Our Ref: AL/33/19/RES
Your Ref:

Application for Approval of Reserved Matters Following Outline Approval

Development Approval of reserved matters following the consent of AL/8/16/OUT (APP/C3810/W/16/3155330) for the erection of 14 No. dwellings with associated access, parking, landscape & open space.

Location Barnside Hook Lane Aldingbourne

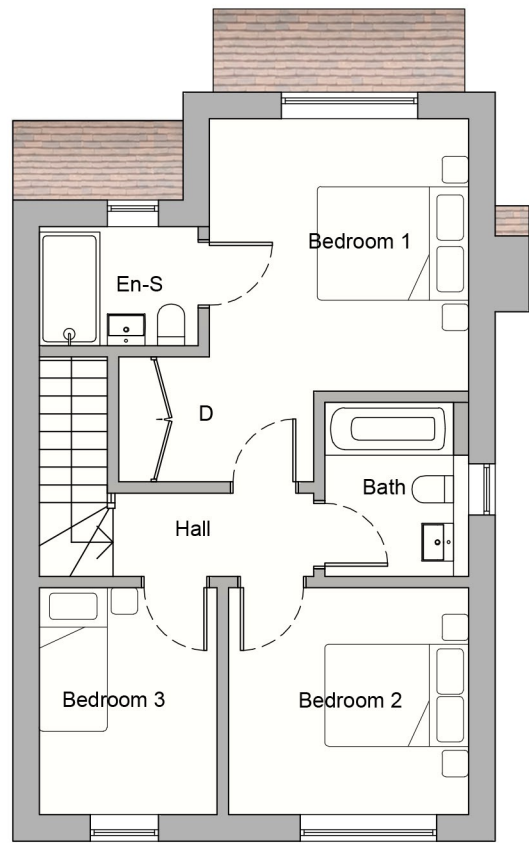
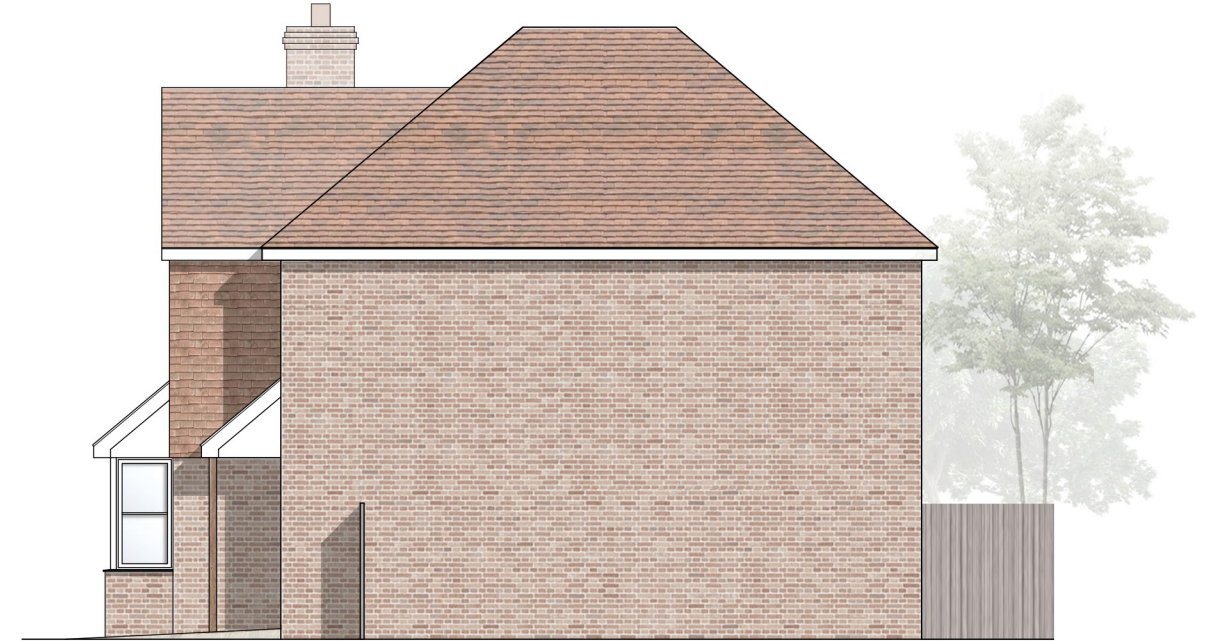
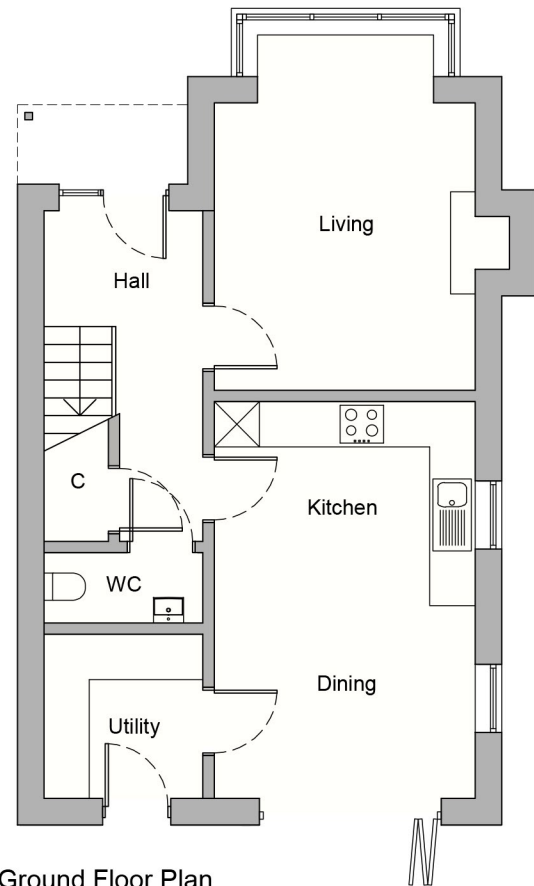
On plot 2, the ground floor and east elevation do not accord. Please amend accordingly.
